PLANNING APPLICATION: 2019/62/90486/W

Demolition of existing dwelling and erection of 8no. dwellings; 120 Laund Road, Salendine Nook, Huddersfield, Kirklees, HD3 3TY

The Coal Authority Response: Material Consideration

Figure 6 Proposed Development Layout Plan

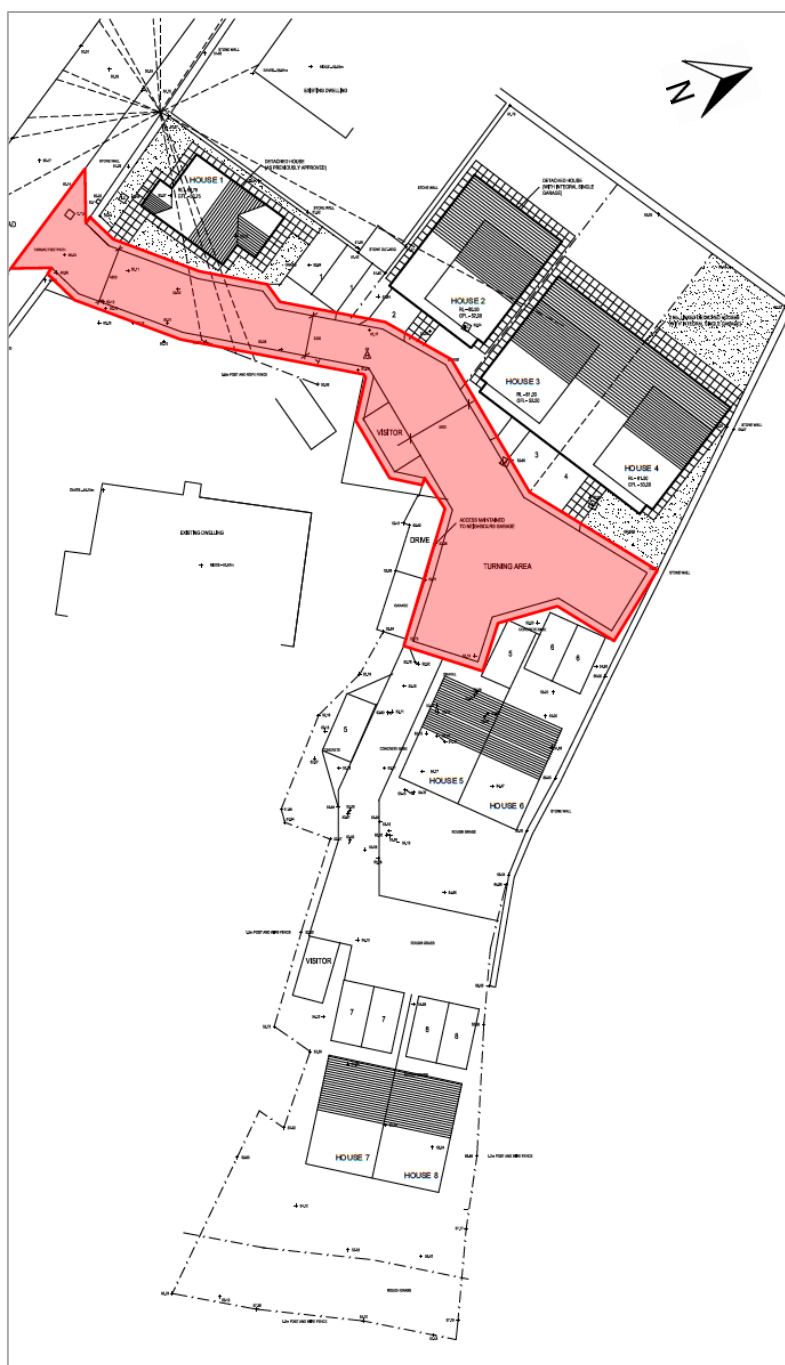
The Coal Authority considers that borehole investigations within the eastern part of the site (incorporating the area upon which plots 5-8 are proposed, as per Drawing 02 – Proposed Site Plan) would be necessary in order to investigate the presence of shallow coal seams, unrecorded workings and the potential for mine gas emissions.

- * The undertaking of the scheme of intrusive site investigations, designed by a competent person and adequate to properly assess the ground conditions on the site and establish the risks posed to the development by past coal mining activity;
- * The submission of a report of findings arising from the intrusive site investigations and any remedial works and/or mitigation measures considered necessary;
- * Implementation of the remedial works and/or mitigation measures.
